KITTITAS COUNTY COMMUNITY DEVELOPMENT SERVICES

October 23, 2013

RE: Larson Fruit Conditional Use Permit Application (CU-13-00007)

The application for a conditional use permit for farm housing on approximately 2 acres of a 21 acre parcel that is zoned Forest and Range, located in a portion of Section 27, T15N, R19E, WM, in Kittitas County, Assessor's map number 15-19-27000-0002, was received on September 26, 2013. Your application has been determined **incomplete** as of October 23, 2013.

SITE PLAN

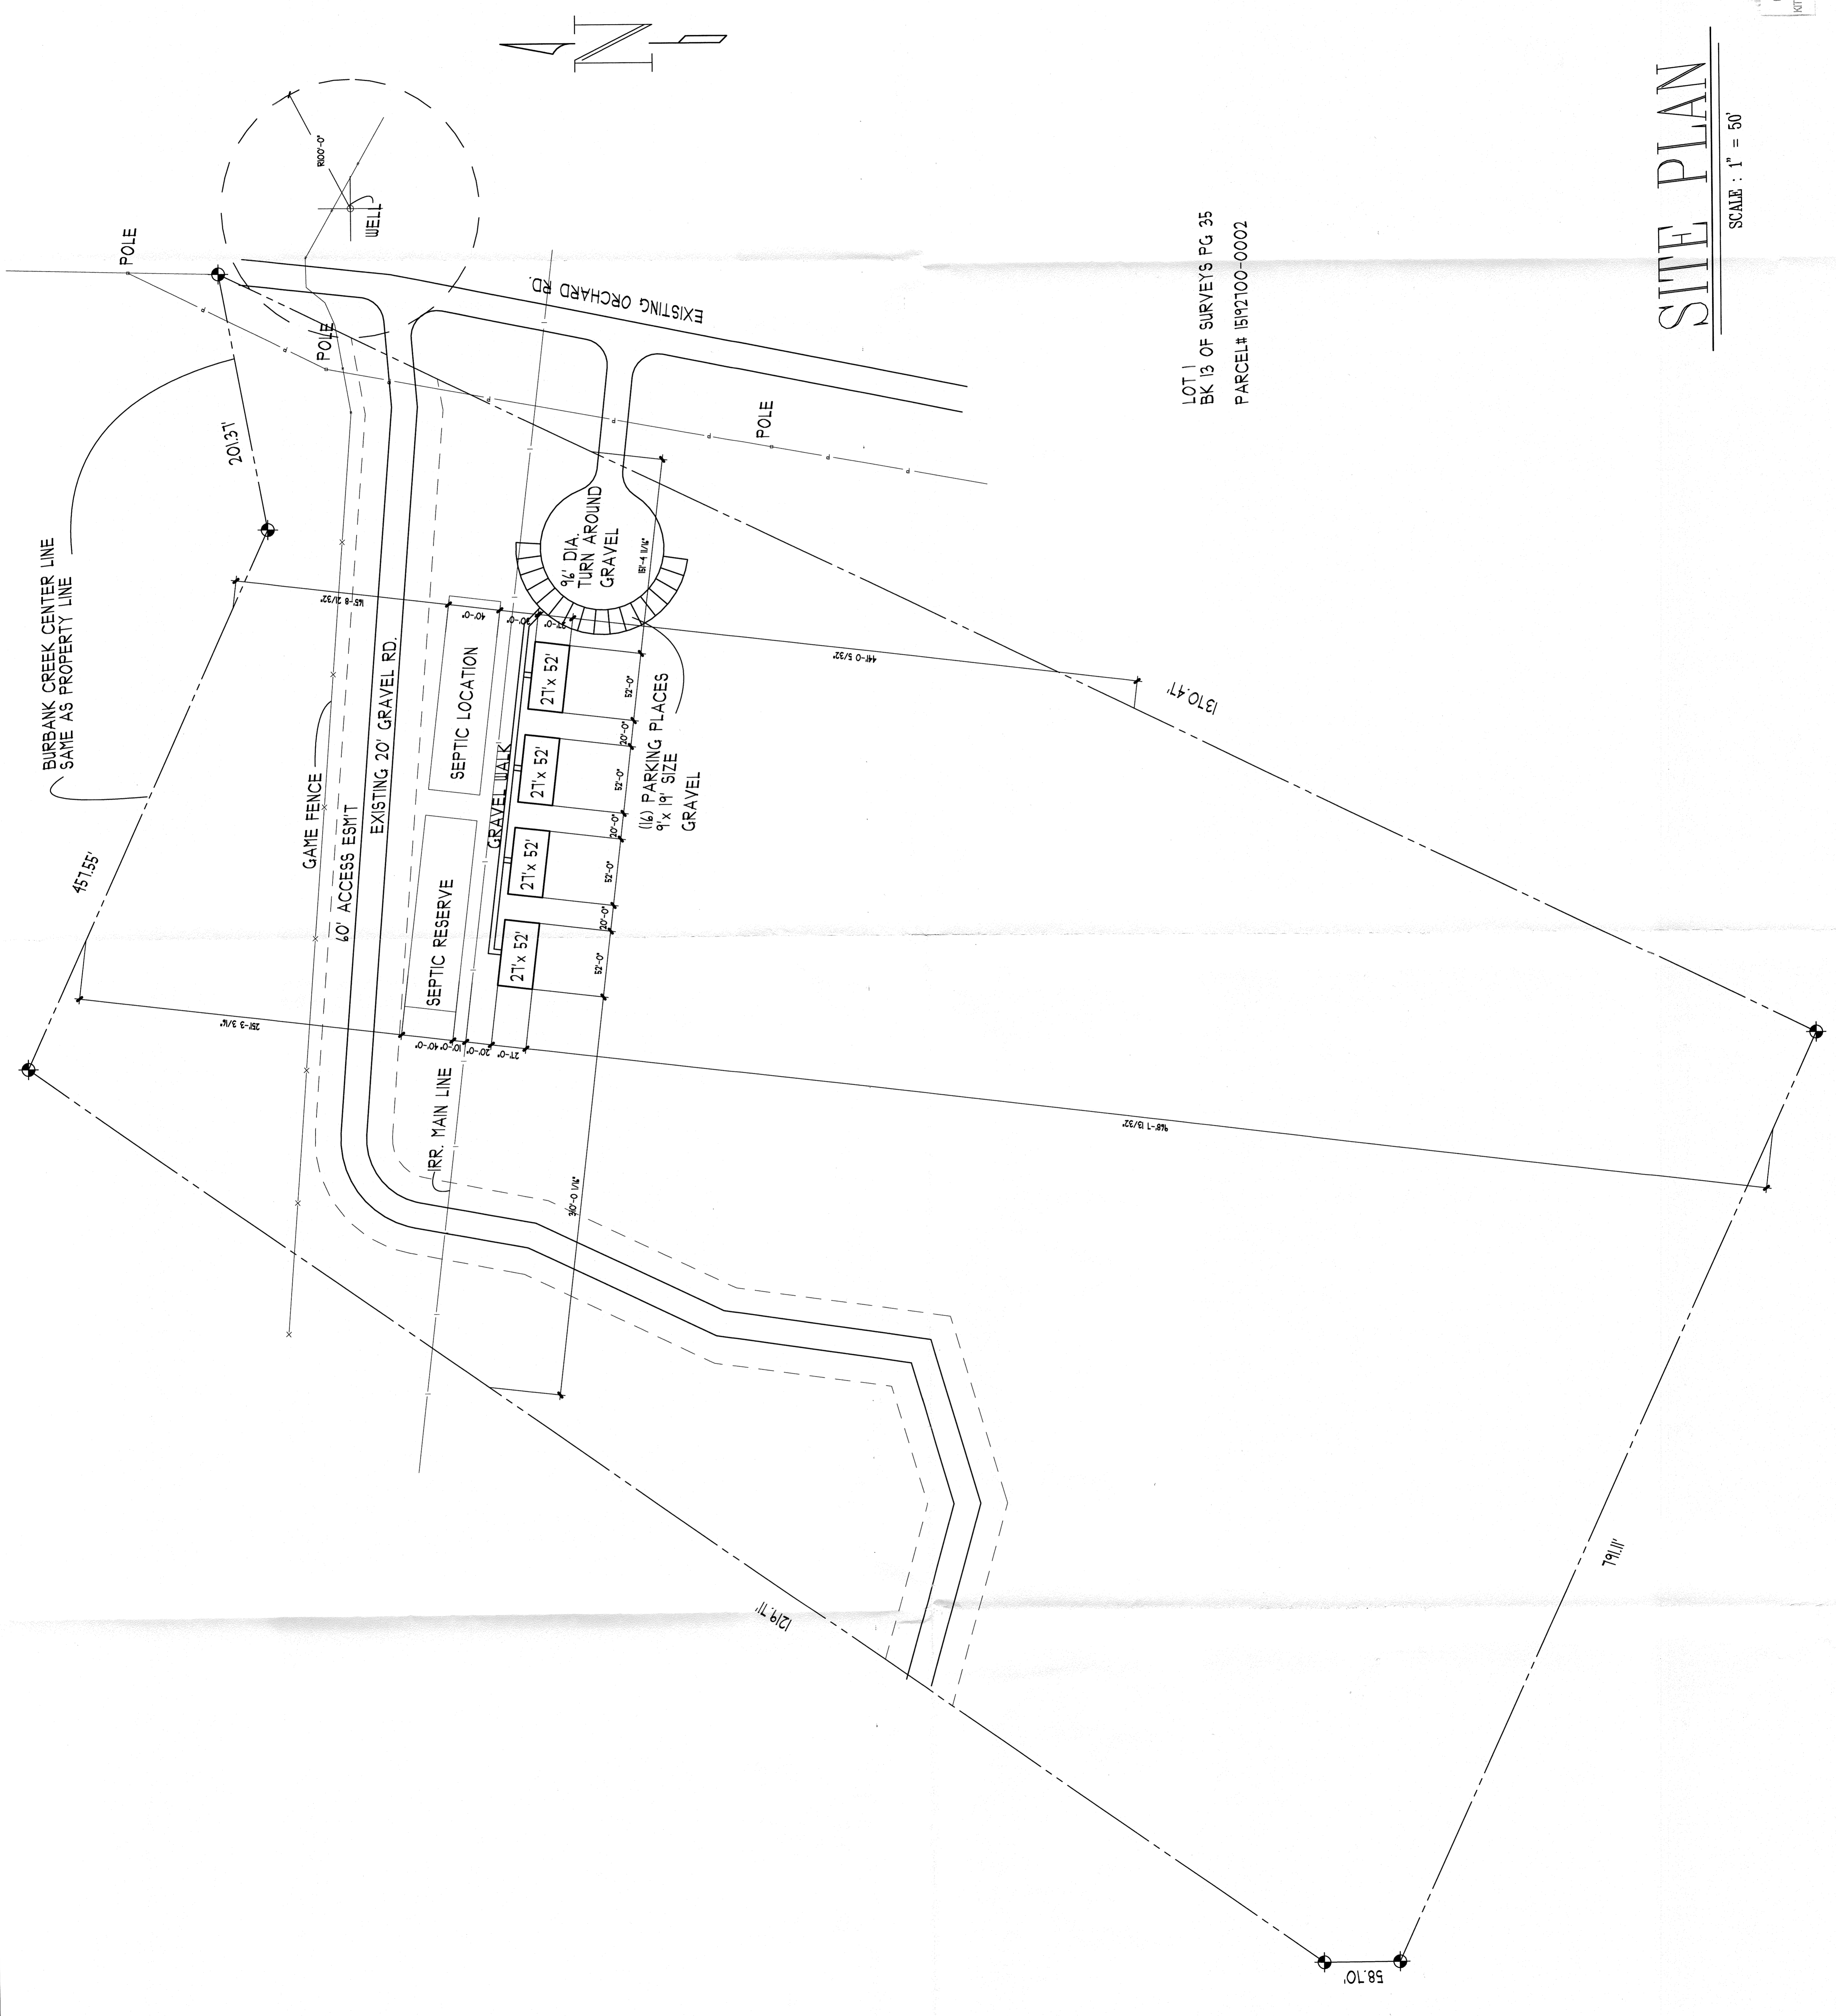
Your application does not meet the requirements of KCC 17.60A.030 for a complete application. This application does not contain a site plan with sufficient detail. Per KCC 17.60A.030 "...the administrator, Hearing Examiner and/or Board may require other drawings, topographic surveys, photographs, or other material essential to an understanding of the proposed use and its relationship to the surrounding properties." Attached to this letter is the site plan that was submitted with notes from our planning official, Doc Hansen. The information necessary for a site plan with sufficient detail includes:

- Scaled drawing no less than 1" = 50' to determine adequacy of:
 - Access/roads
 - Parking
 - Septic distances
 - Septic tank(s) and reserve locations
 - Scale of turn-around in relation to buildings & lot
 - Distance from waterways (Burbank Creek)
 - Entire parcel boundary with dimensions

NEED:

- 1) SCALED DRAWING NO LESS THAN 1"=50' TO DETERMINE ADEQUACY OF ACCESS/ROADS
- 2) PARKING
- 3) SEPTIC DISTANCES
- 4) RESERVE & SEPTIC LOCATIONS
- 5) SCALE OF TURN-AROUND IN RELATION TO BUILDINGS & LOT
- 6) DISTANCE FROM WATERWAYS/BURBANK
